Recommendation Report for Planning Permission for Works or Extension to a Dwelling

REF NO: **AW/286/15/HH**

LOCATION: 14 Bradlond Close
Aldwick

PROPOSAL: Single storey extension to form ancillary annexe accomodation for family member - Resubmission of AW/182/15/HH

PROPOSED ELEVATIONS

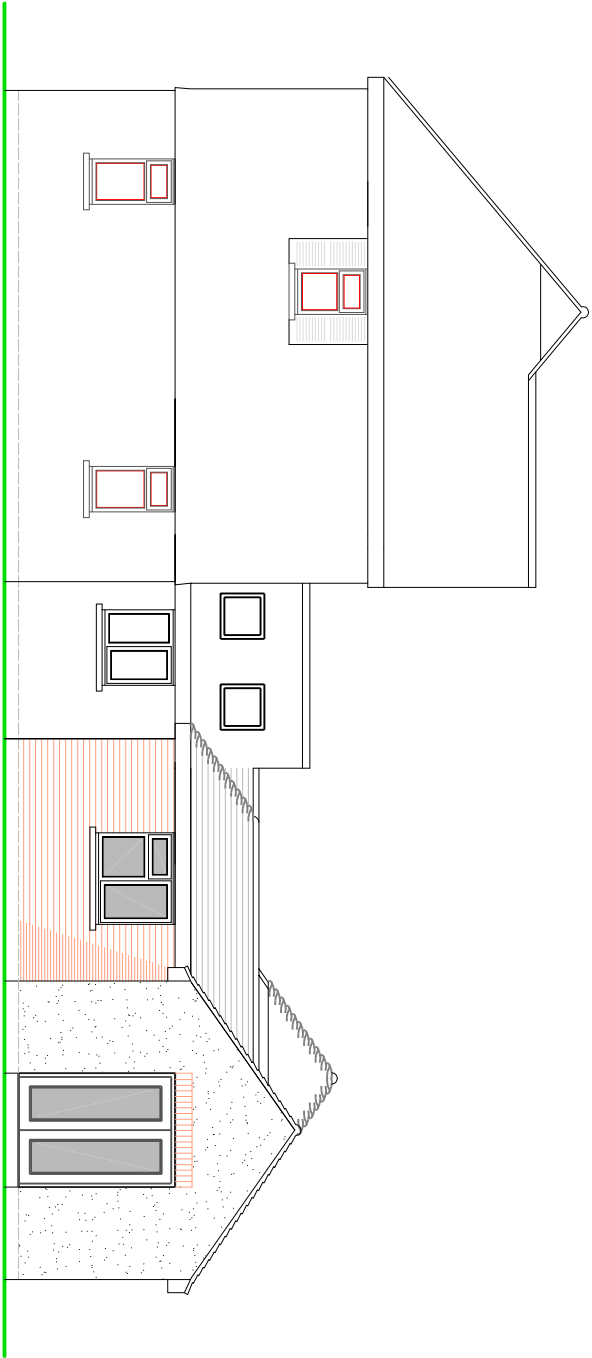
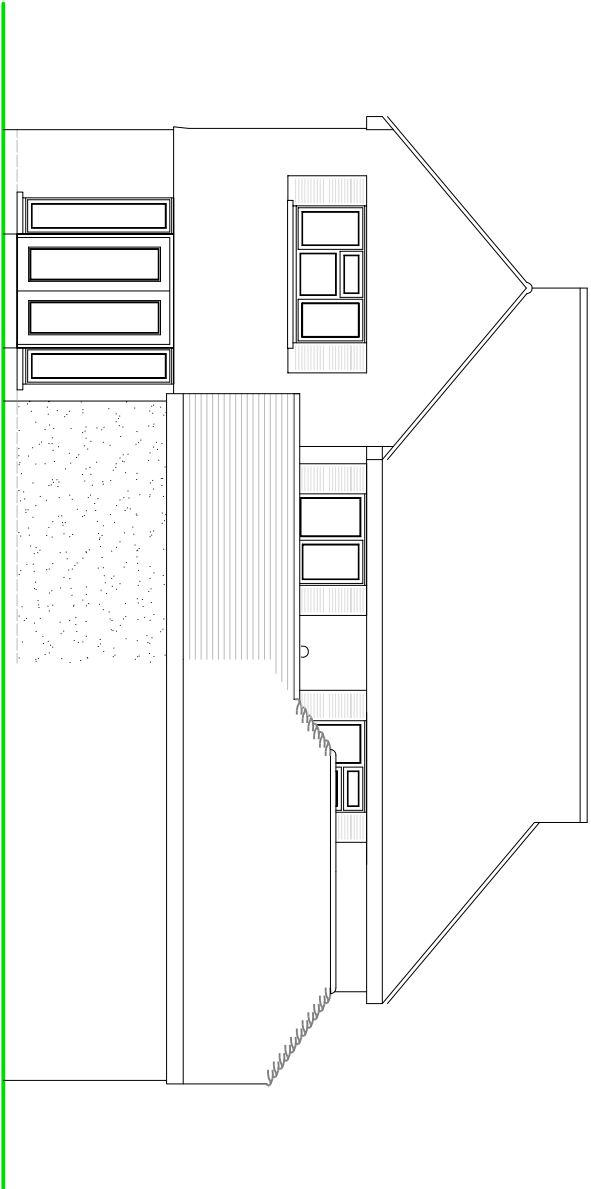
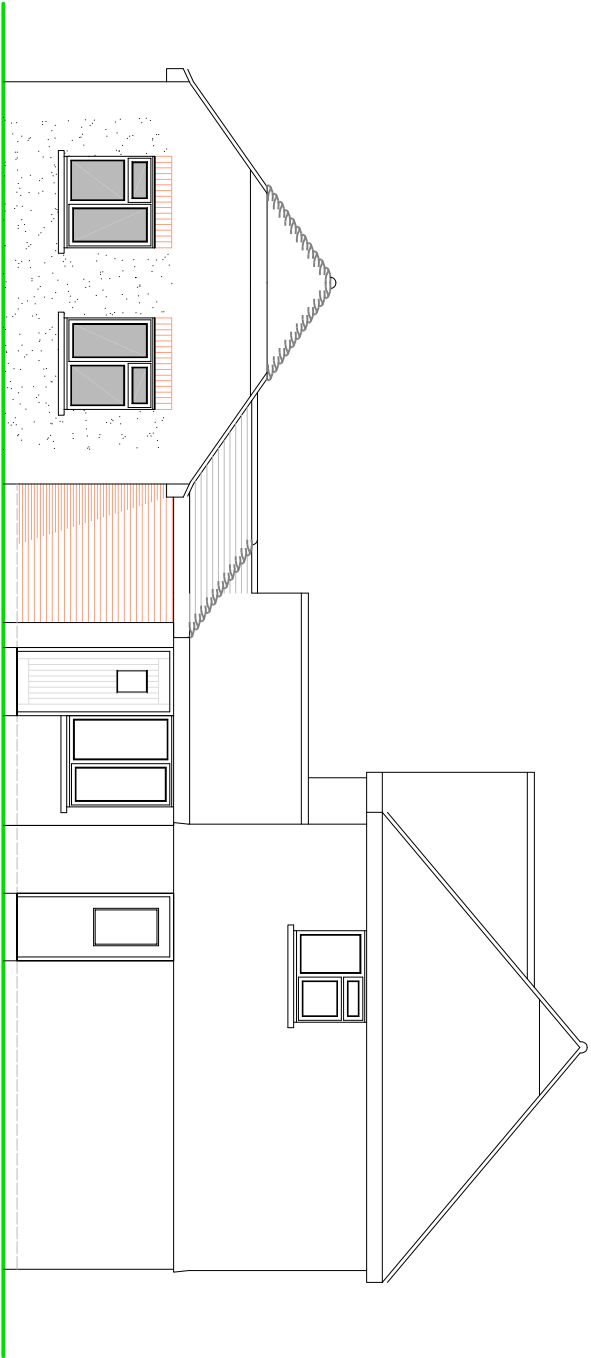
The proposed extensions are less prominently located than the previous scheme. There will still be a side extension, linking the garage to the porch, visible from the street scene but the appearance of the house will not be significantly altered. The overall form of the side garage will be retained and the appearance of the house as a detached dwelling is largely sustained. As such the uniform character of the street scene will not be dramatically altered in line with the requirements of the Aldwick Village Design Statement.

The extensions and conversion will be subservient to the main dwelling, materials to match existing will be ensured via condition and the proposed front windows will be similar in appearance to the windows of the existing house.

- 2 The materials and finishes of the external walls of the annexe hereby permitted shall match in colour and texture those of the existing dwelling and garage.

PROPOSED GROUND FLOOR PLAN

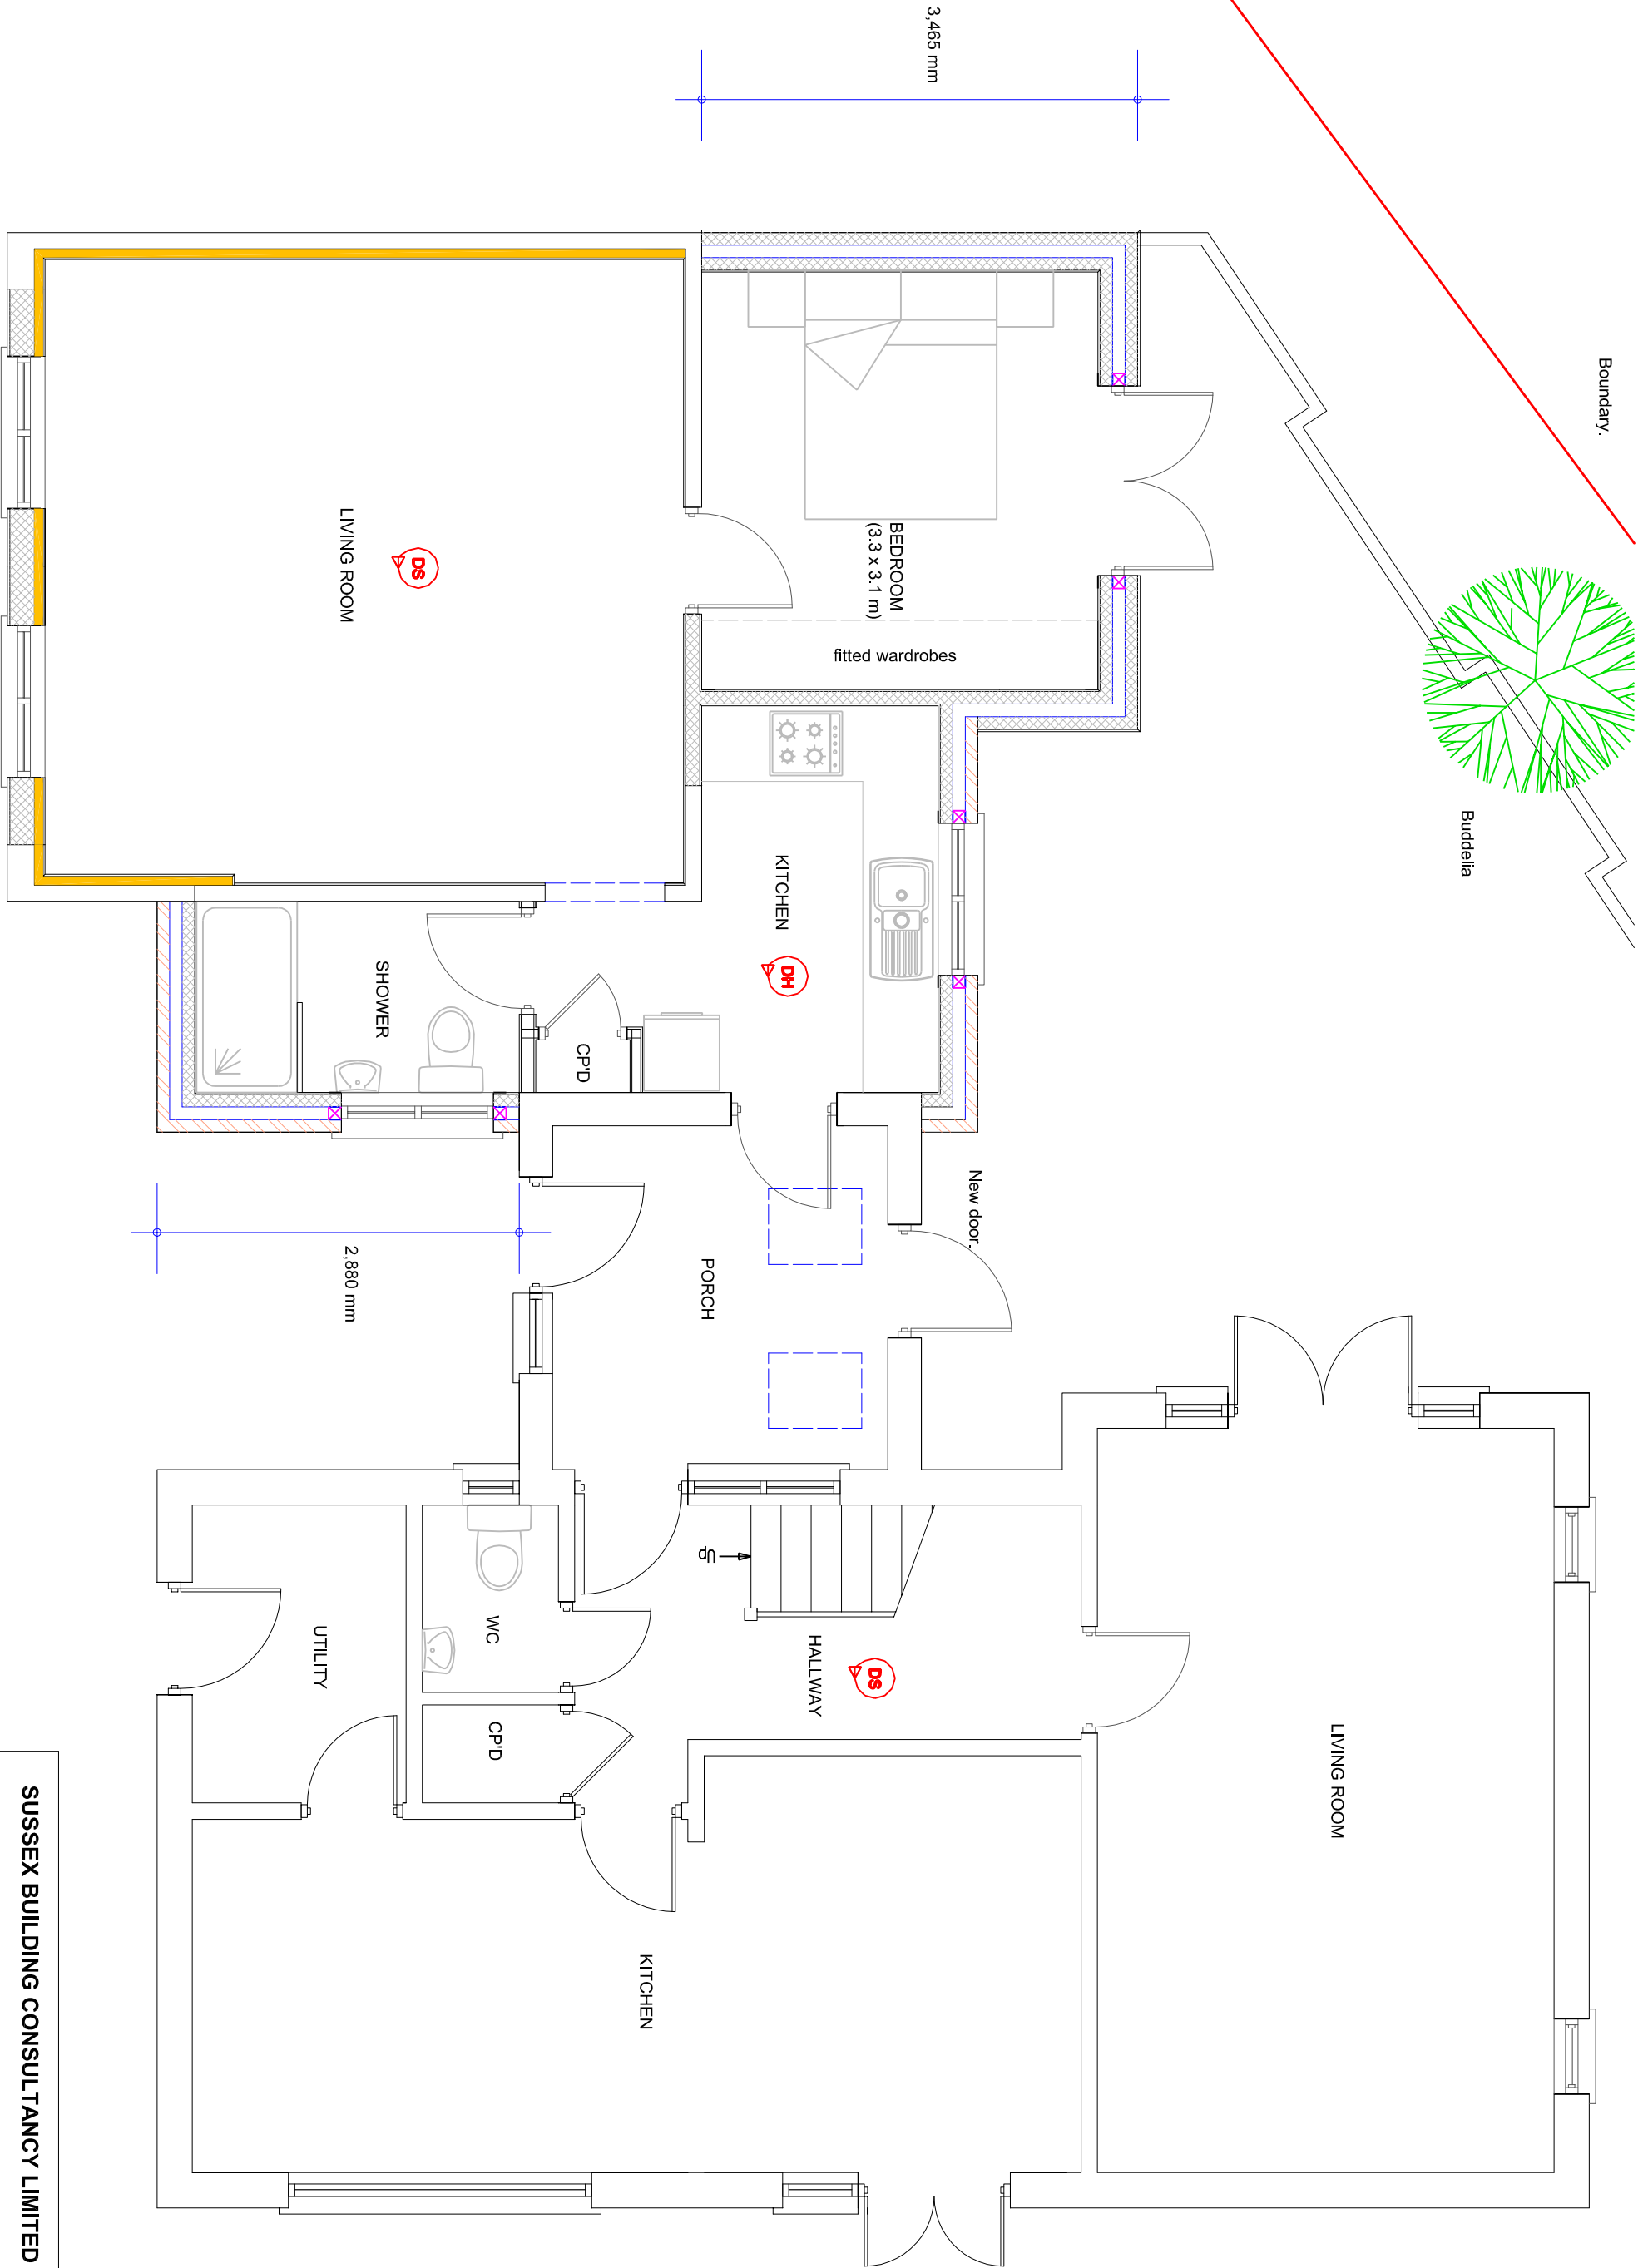
Owing to the location of the extension between and behind the existing garage and house and the site being a corner plot, no neighbouring dwelling would receive a direct impact from the proposal. As such it is considered to be acceptable in terms of neighbouring residential amenity.

Whilst the proposal will reduce the amount of off street parking from 3 spaces to 2, the area is not heavily parked on street. As such with 2 spaces being retained it is not considered that the

proposal would lead to undue on street parking which could lead to highways danger.

- 4 The annexe hereby permitted shall be occupied solely for purposes incidental to the occupation and enjoyment of 14 Bradlond Close, Aldwick as a dwelling and shall not be used as a separate unit of accommodation.
